**Re: Objection to MP08\_0244 MOD 1 Modification Request for Mixed Used Development at 23-37 Lindfield Avenue and 11 Havilah Lane, Lindfield**

As a resident of Lindfield, I/we wish to lodge an objection against the proposed Modification of the subject development based on the following grounds:

ELEVATIONS

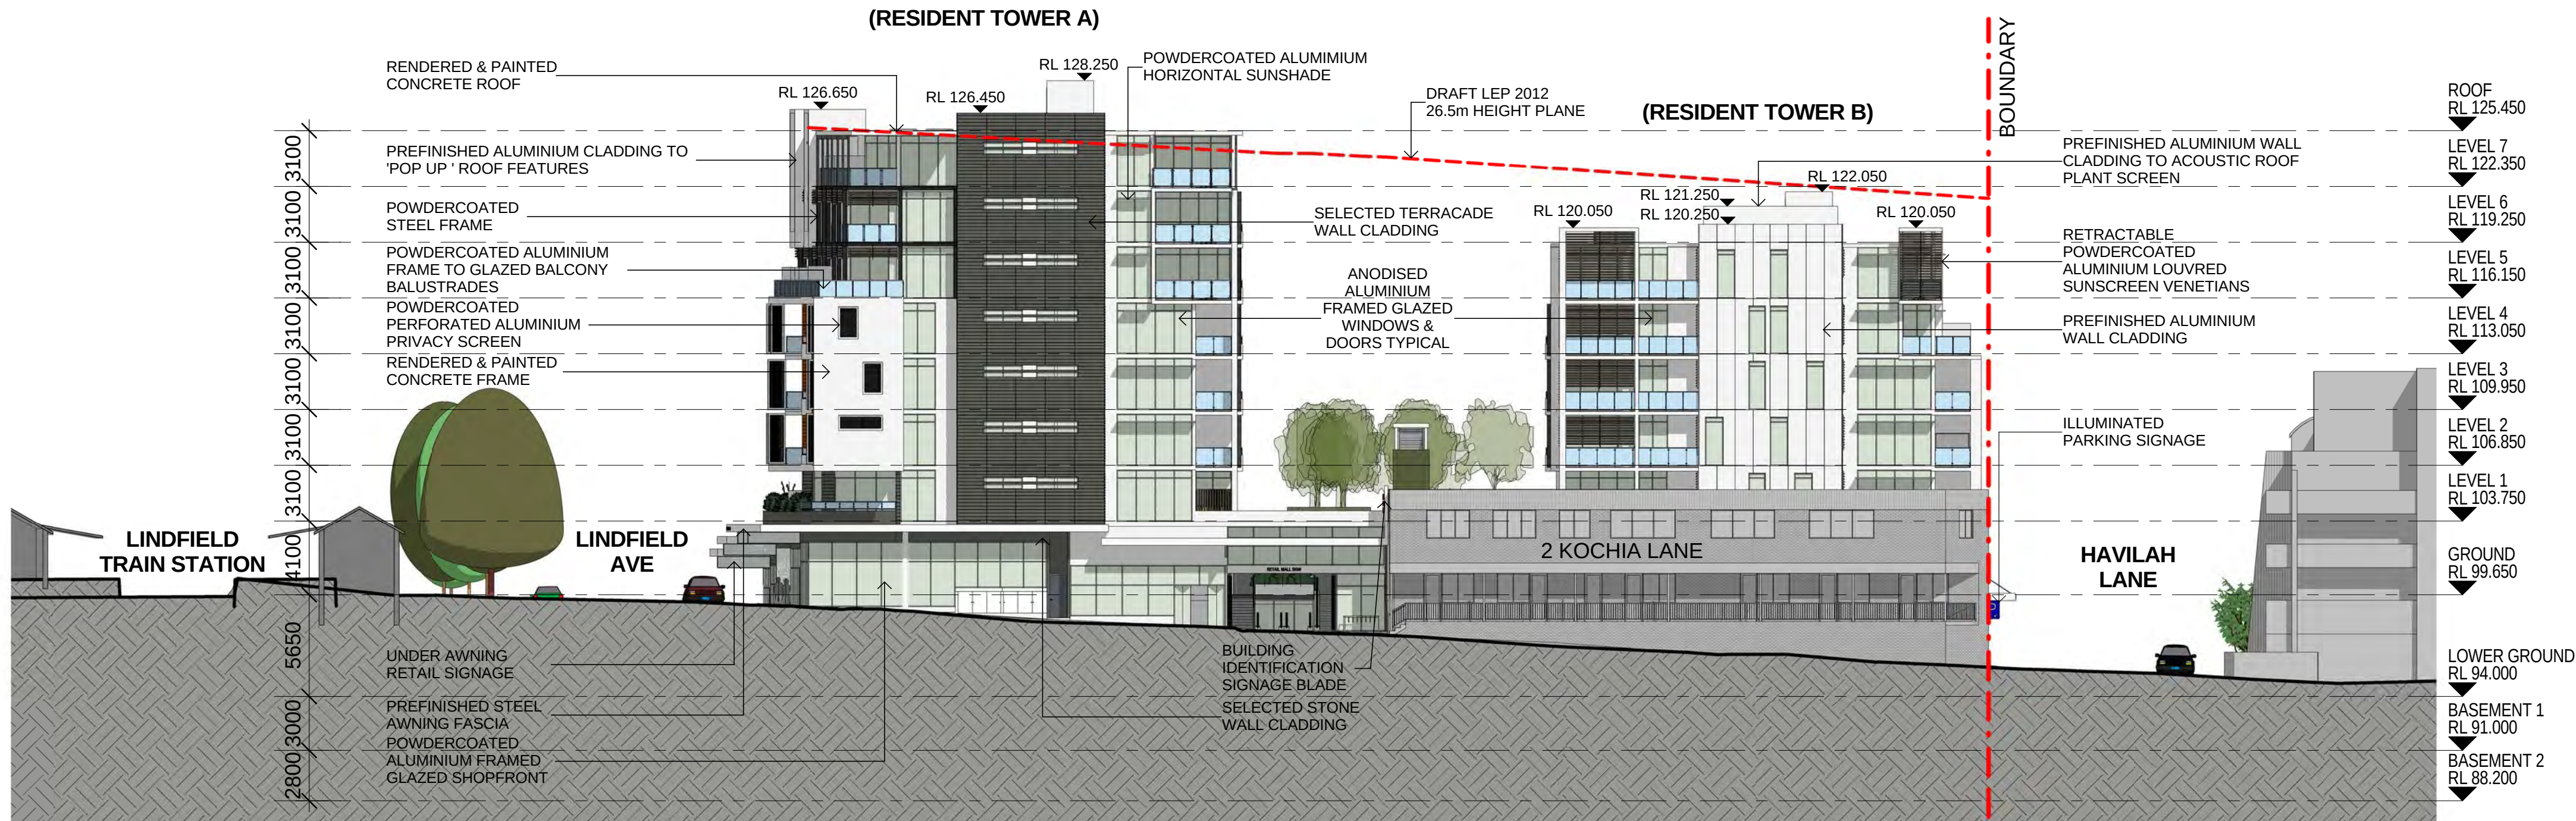
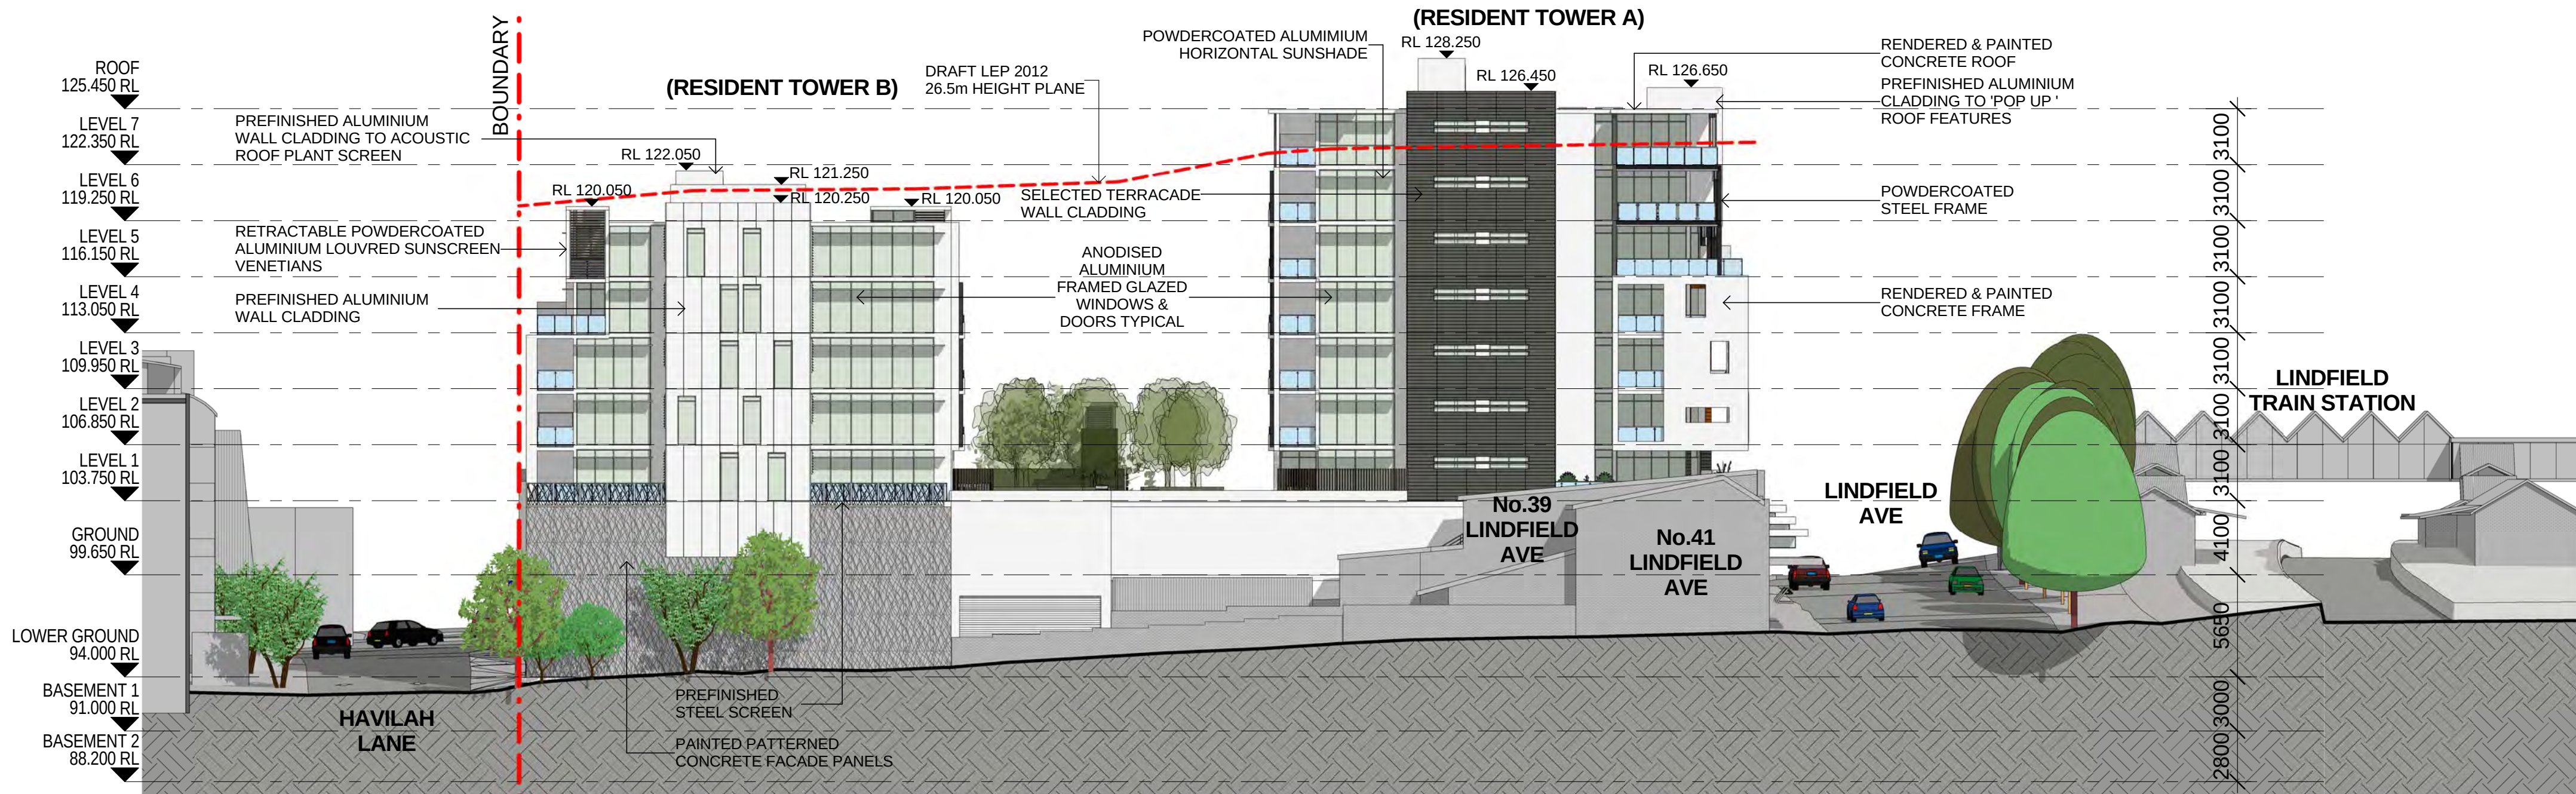
- The increase of an additional storey to both buildings: 8 storeys on Lindfield Avenue and 7 storeys on Havilah Lane creates excessive height and bulk and is out of character with the surrounding buildings, including the heritage listed adjacent building on Lindfield Avenue

- The additional storey (combined with less set back than the approved design) on Havilah Lane now creates privacy concerns for over 40 apartments in the adjacent 8 Havilah Lane, 8 Kochia Lane and 2-8 Milray Street residences
